Please ask for: Nicola Moore
Email: nicola.moore@arun.gov.uk
Telephone: Ext 37944
Our Ref: WA/15/22/PL
Your Ref:
Date: 14th February 2022

Application for Planning Permission

Development: Removal of the existing tiles, battens and felt of the west wing roof and replace with new (like for like). This application is on CIL Zone 3 9zero rated) as other development. This application may affect the character and appearance of the Walberton Village Conservation area and affects the setting of a Listed Building.

Location: Walberton Park The Street Walberton BN18 0PJ

Existing Roof Plan View
(1:100)

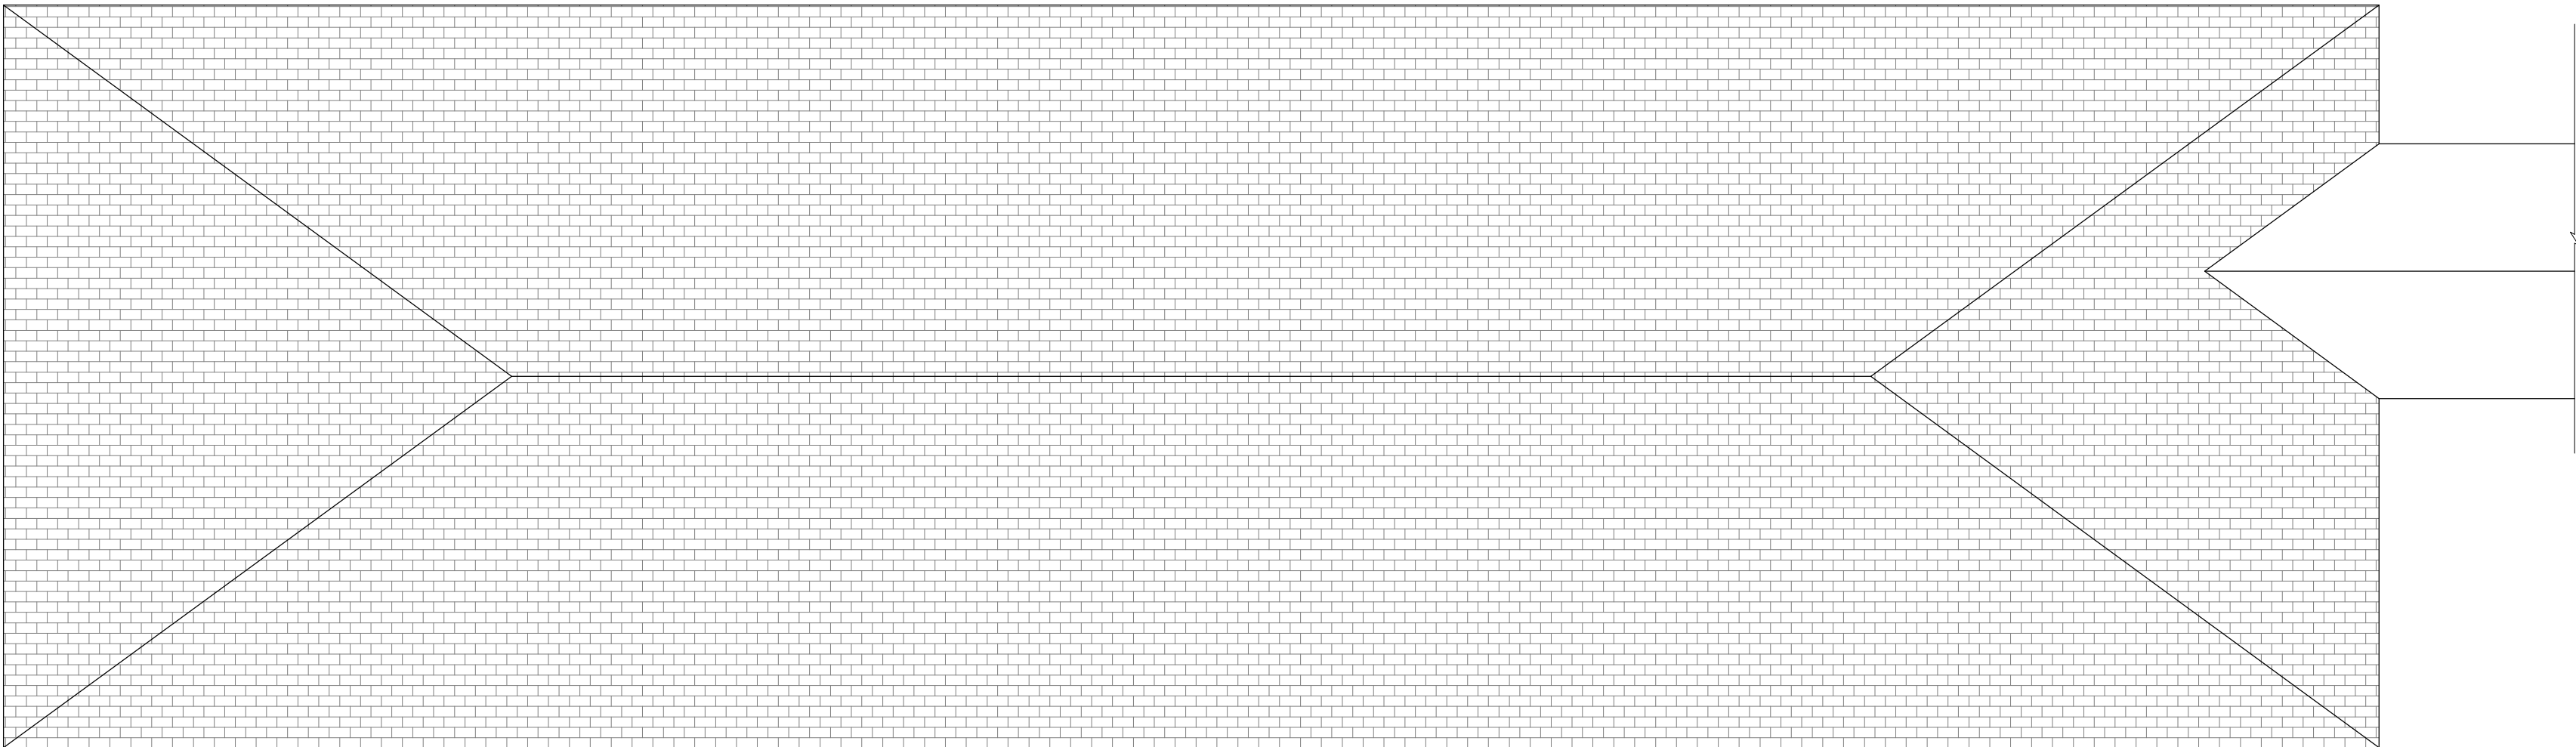
Roof Plan

Please submit electronic plans showing the existing roof plan. Please refer to the Validation Requirements List for further details.

Block Plan
(1:500)

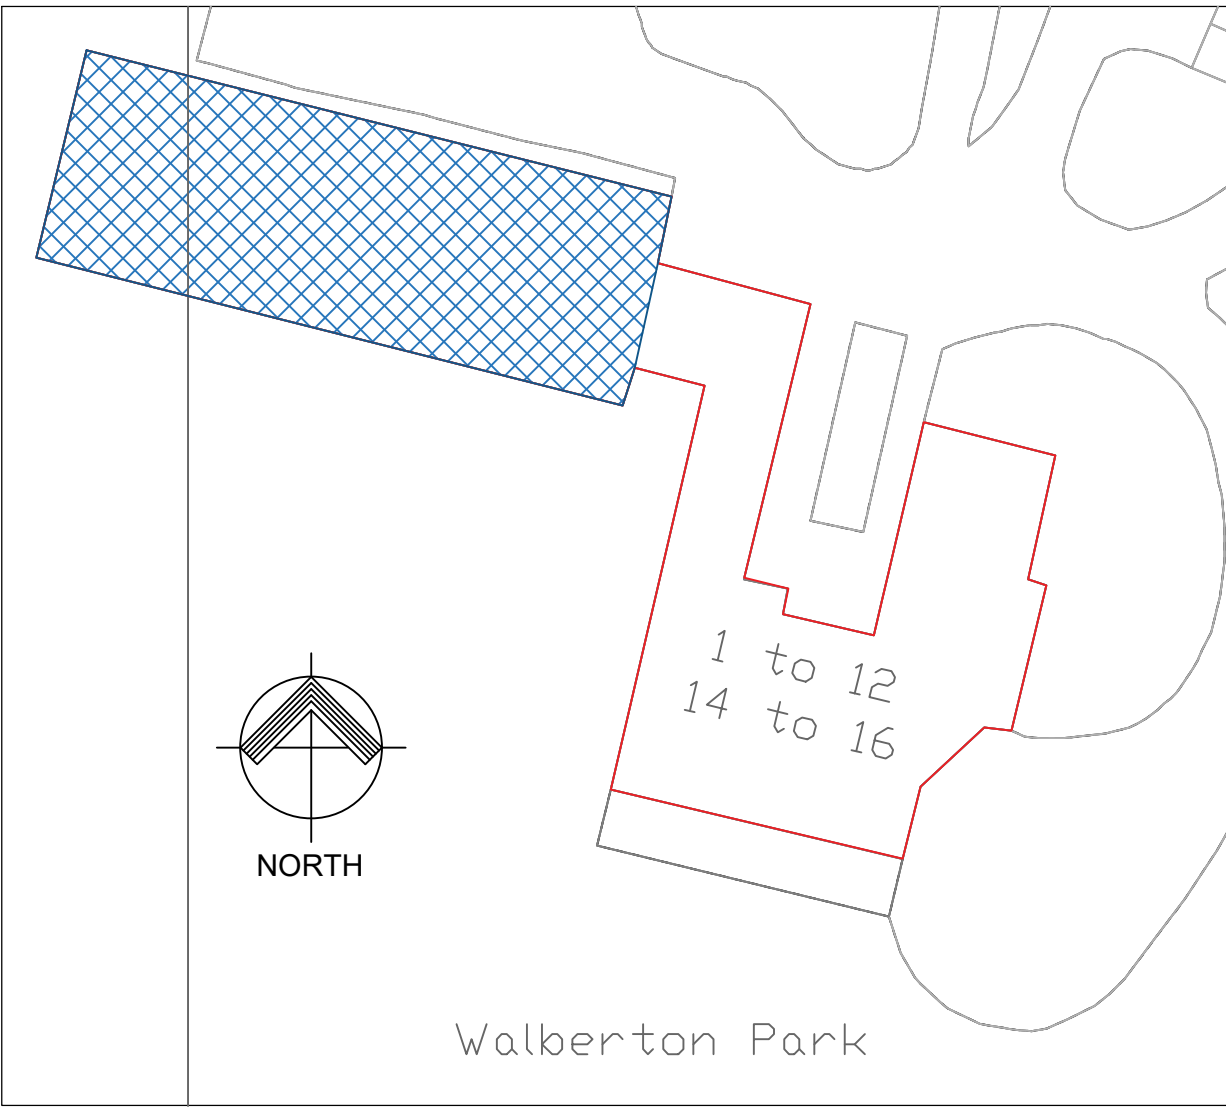
Block Plan

The Block plan should clearly indicate the proposed works (this can be hatched, colour and/or bold), and include a North Point. Please amend accordingly and re submit. Further details of what must be included on the plan can be found in the Validation Requirements List.

Location Plan
(1:1250)

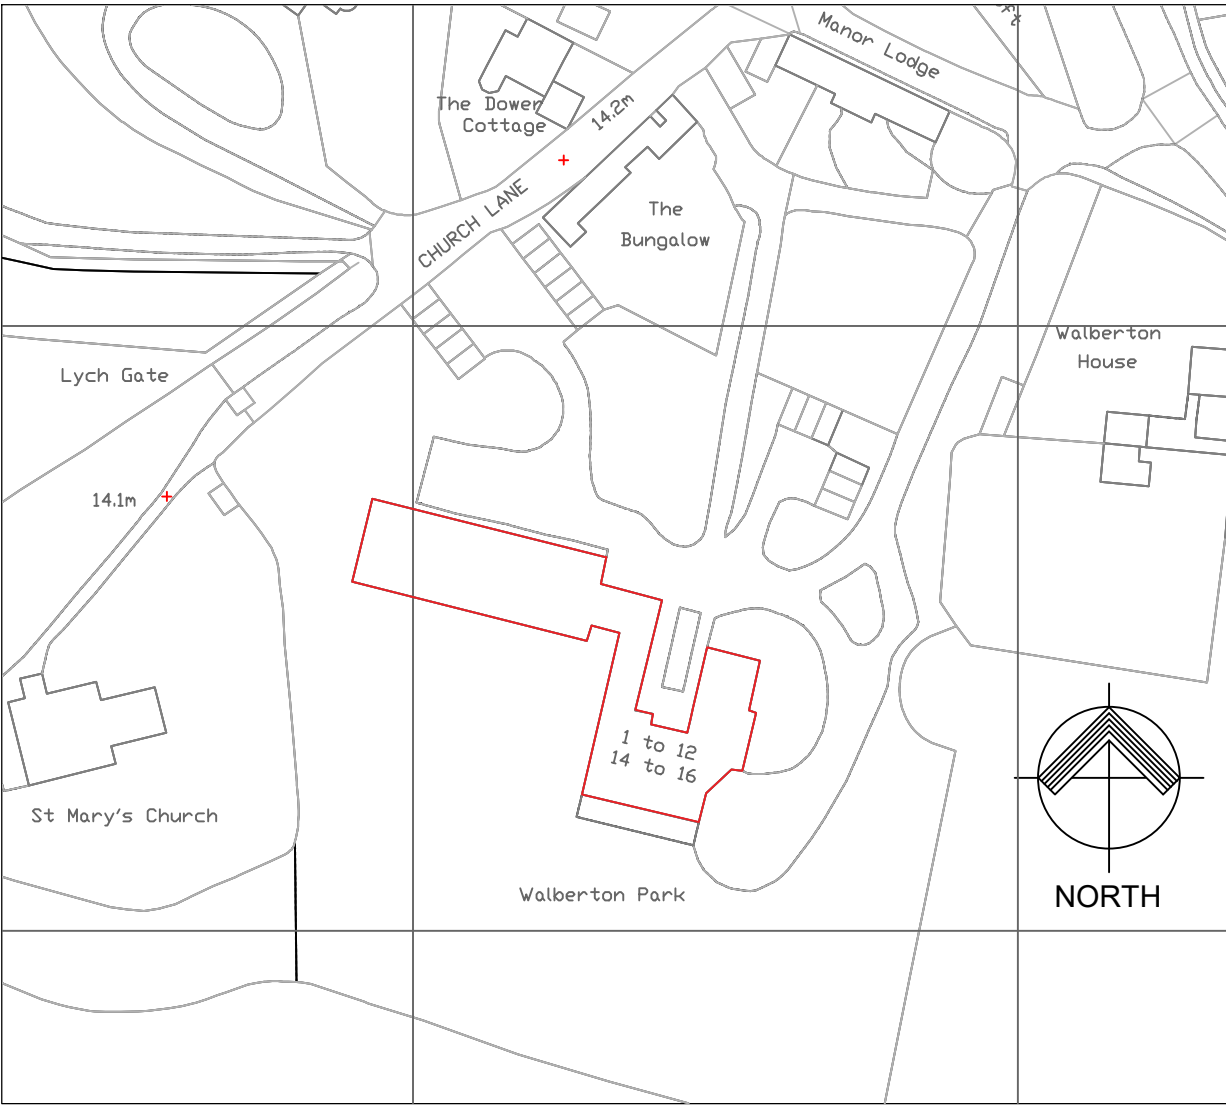
Location Plan

The application site must be edged clearly in red and include a North Point. Please amend accordingly and re submit. Further details of what must be included on the plan can be found in the Validation Requirements List.
